Our Ref: EN020017

Date: 31 March 2017

**Application by National Grid Electricity Transmission plc ("the Applicant") for
an Order Granting Development Consent for the Richborough Connection
Project**

**REQUEST FOR COMMENTS FROM THE APPLICANT, THE CROWN ESTATE,
SOUTH EAST WATER, LOCAL COUNCILS, THE ENVIRONMENT AGENCY,
SOUTHERN WATER SERVICES AND UK POWER NETWORKS**

Inset 3C.1.1: Likely Roles of Environmental Project Construction Team

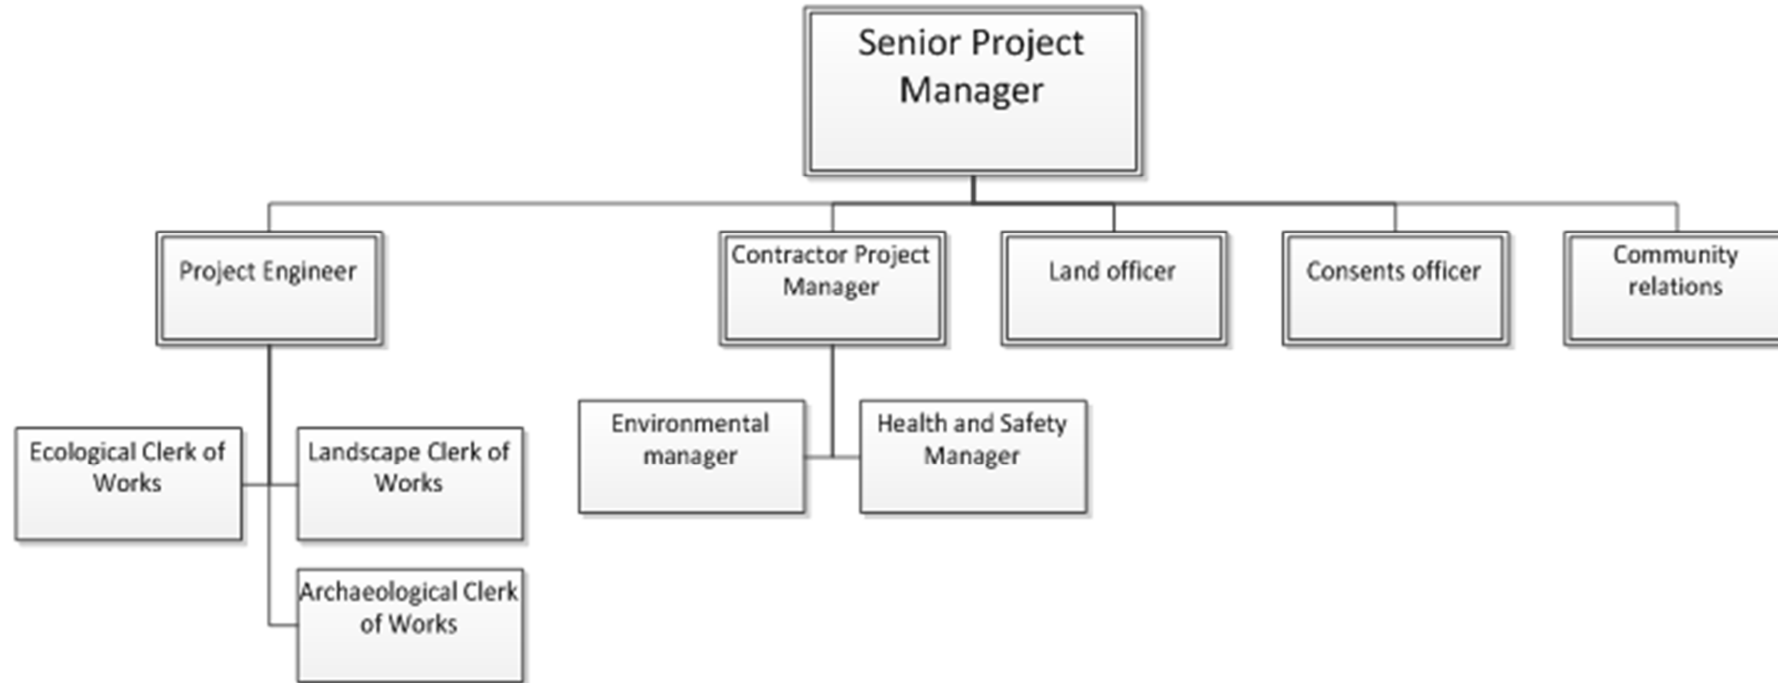
The Secretary of State notes that the Construction Environmental Management Plan ("CEMP") submitted by the Applicant to the Planning Inspectorate for Deadline 7 in November 2016 [REP7-018 in the Document Library on the Planning Inspectorate's Richborough project page] did not contain any reference to the provision of a Land Drainage Consultant which had been raised by the Applicant in its submissions to the Examining Authority, most recently in the "Applicant's Response to points raised in 3rd party submissions at Deadline 5 October 2016" (at section 3, paragraph 2.5) [Document Library REP6-016]. The Secretary of State would be grateful if the **Applicant** could include a relevant reference to the Land Drainage Consultant in Table

3C.2.4 at paragraph 2.11.3 of the CEMP and in the construction team diagram at Inset 3C.2.1 and provide updated versions of these documents to the Secretary of State.
